May 12, 2021

**RE: Bradley Heights PUD Development Plan – Initial Review Comments**  
**File # AR PUD 21-00206**

The proposed project involves a PUD development plan to enable development of a vacant parcel into 168 single-family residences. Staff finds that the application is largely acceptable; however, the following technical modifications must be completed.

**CUSTOM COLLECTOR -
BRADLEY LANDING BLVD.**
NOT TO SCALE

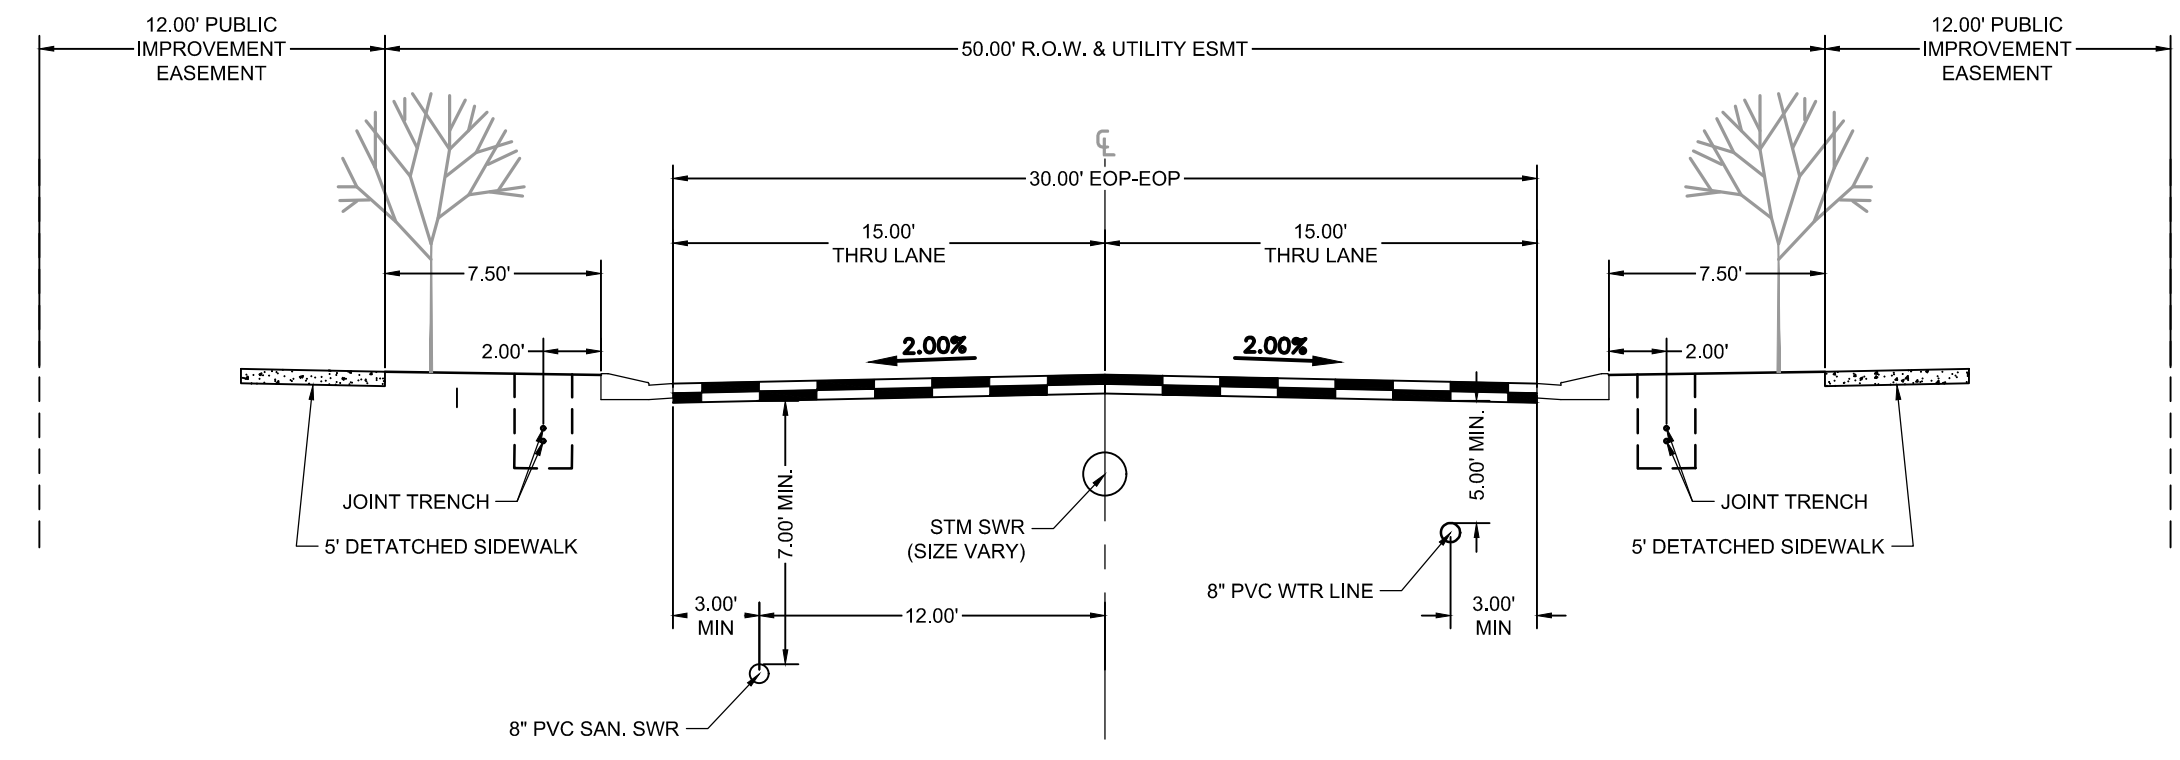
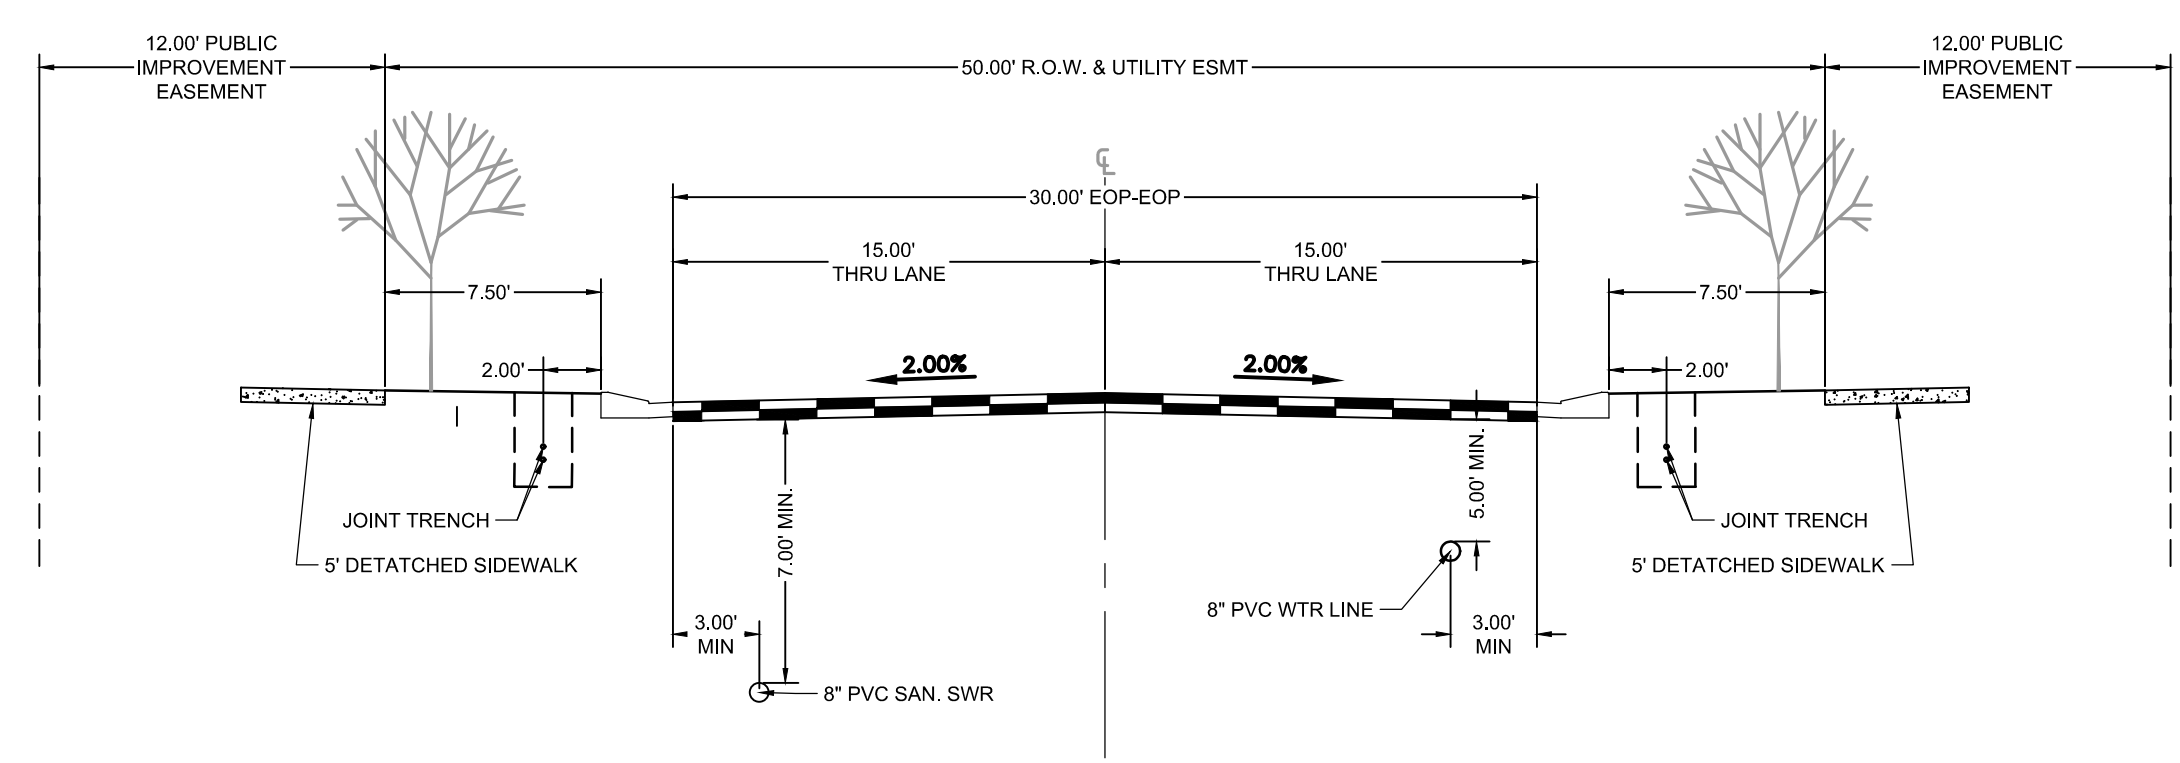
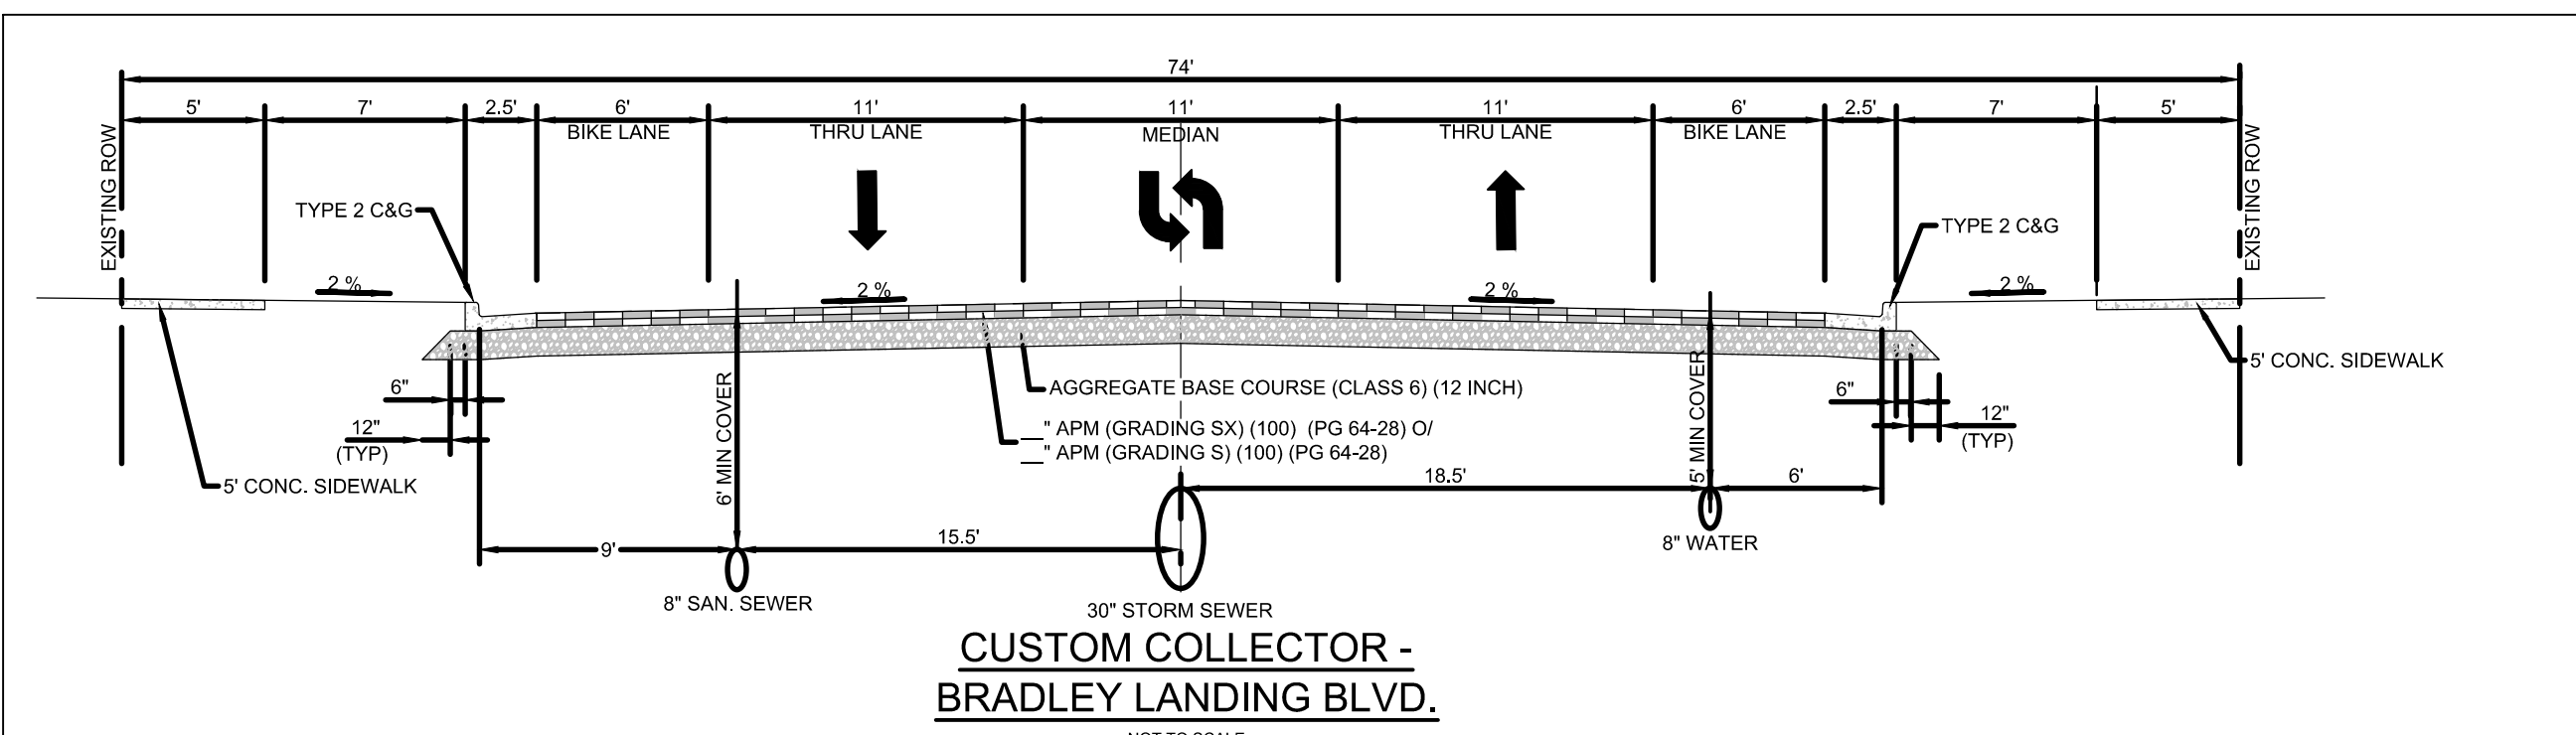
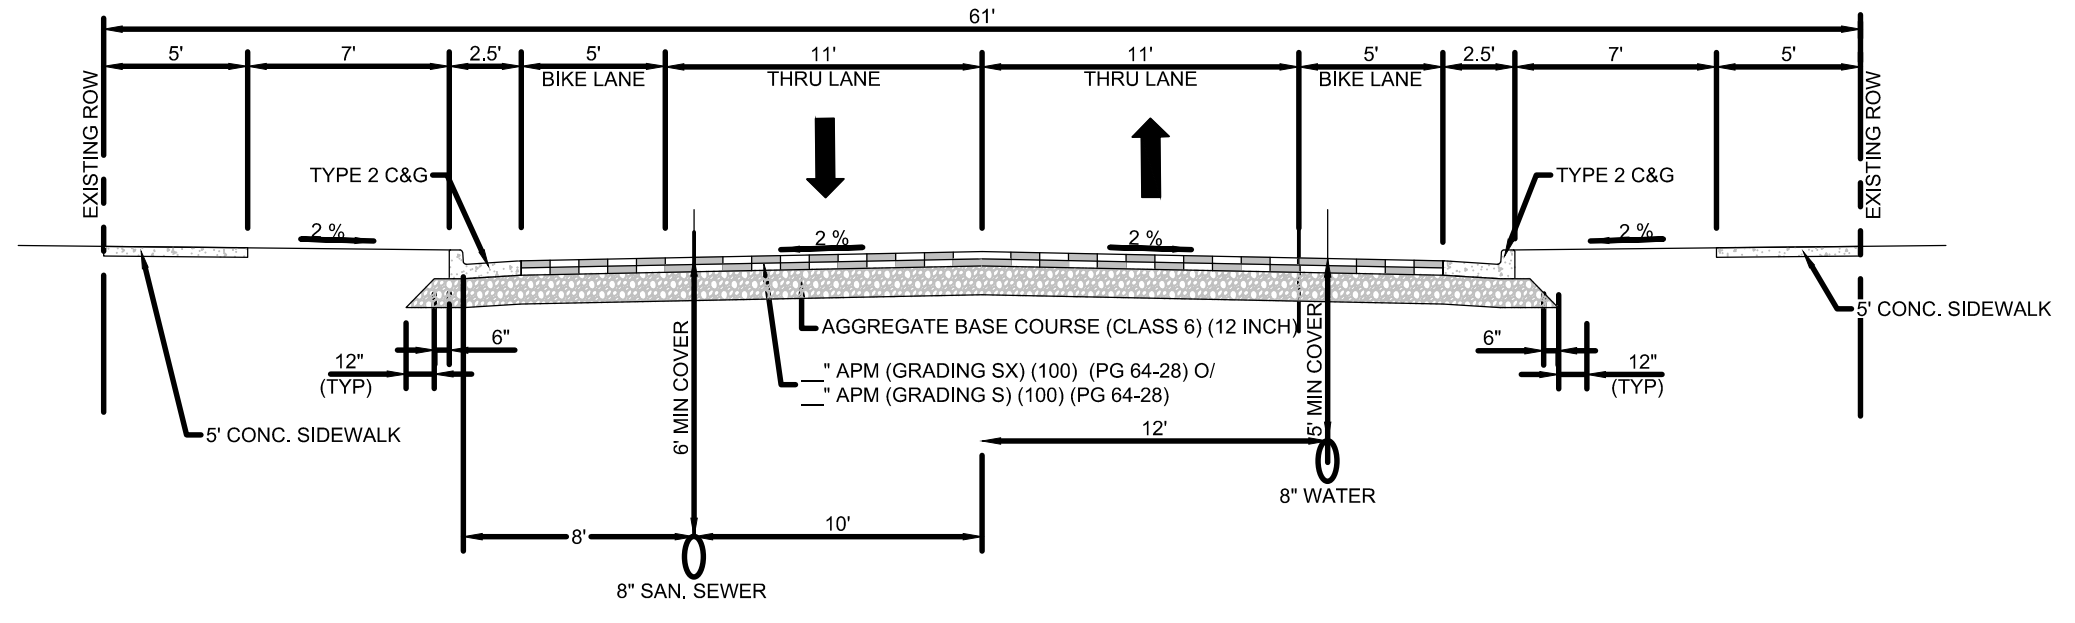
3. Please revise cross sections to reflect the new approved cross sections.
  4. Per city code water and wastewater mains must be extended to furthest extent of property. Please revise appropriately for Filing No 2 down Bliss Dr.

2. On Sheet 2, the residential and collector cross-sections. The joint gas and electric trench is now under the sidewalk. Update the cross-sections. Typical street cross-sections can be found in City Engineering's standard details. Include a cross-section for the Bradley Landing Blvd (Minor Arterial).

CHALLENGER HOMES
 PUD DEVELOPMENT PLAN
 OVERALL SITE DISTANCE & PHASING PLAN
 SHEET **OV** 4

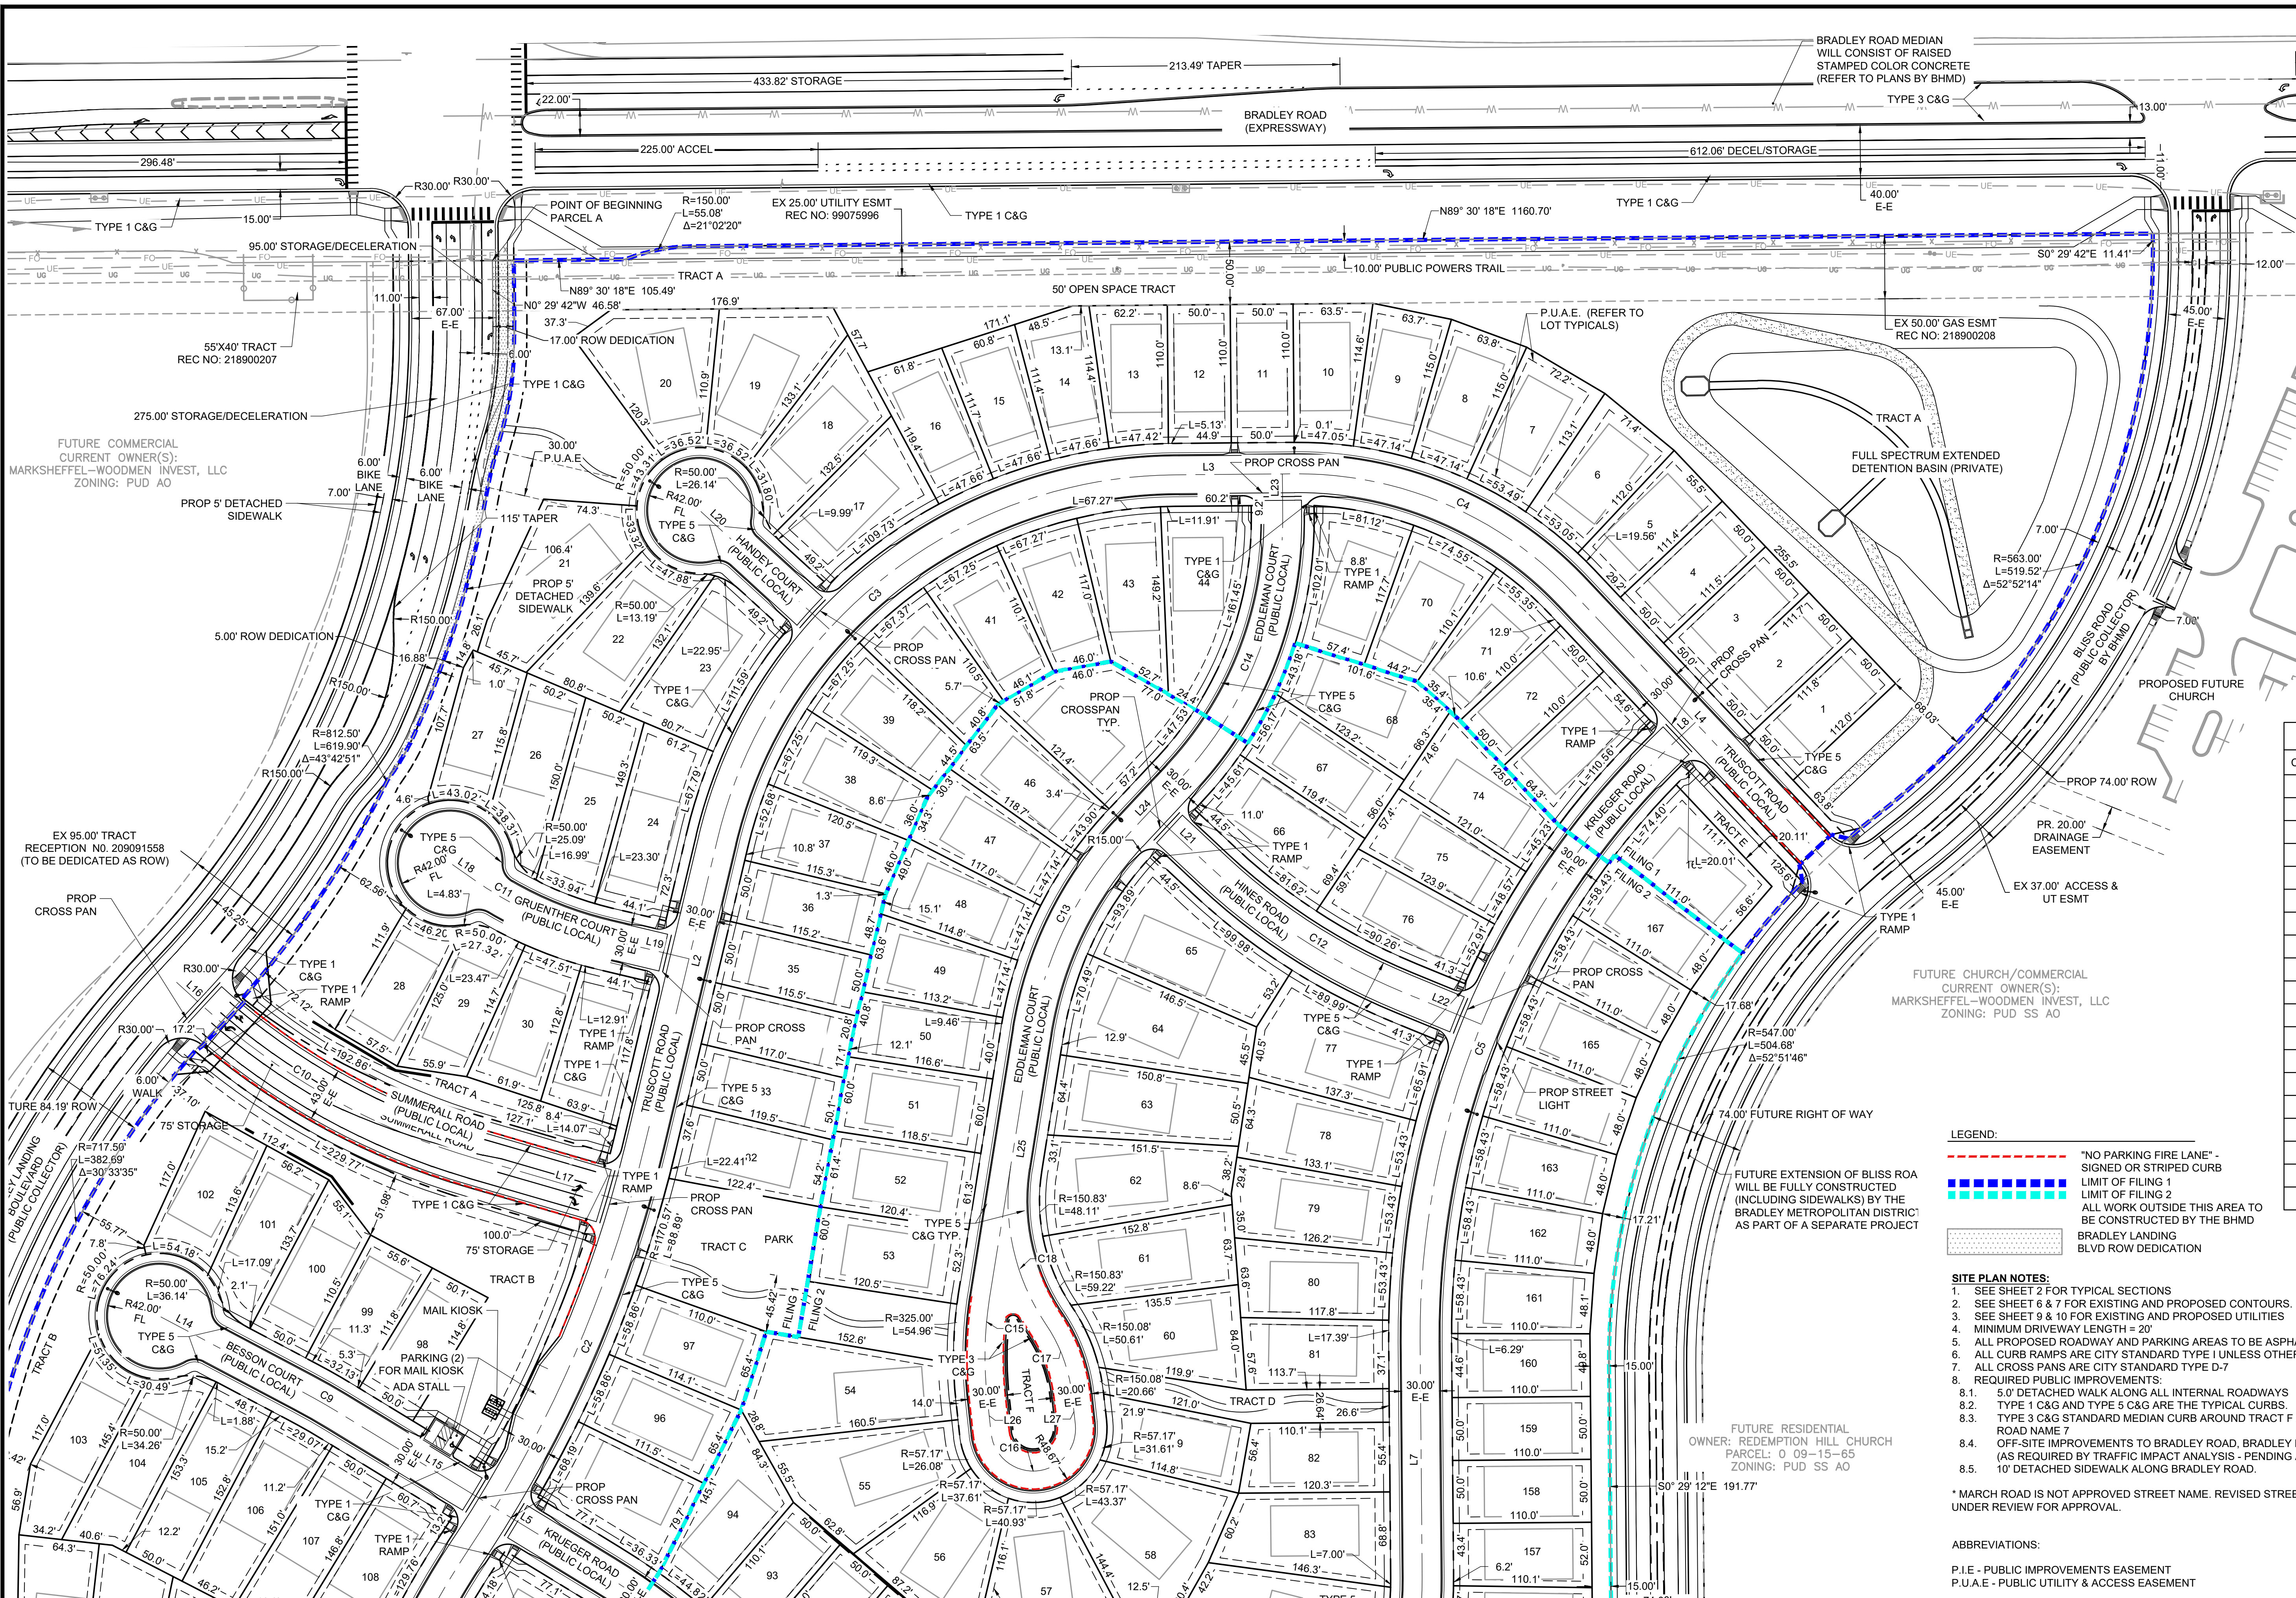
5. Remove note on sheets 4 and 5 stating minimum driveway length is 15 feet. Minimum must be 20 feet.
6. Confirm whether any retaining walls are to be utilized? If so, show on grading plan and denote T.O.W. and B.O.W.
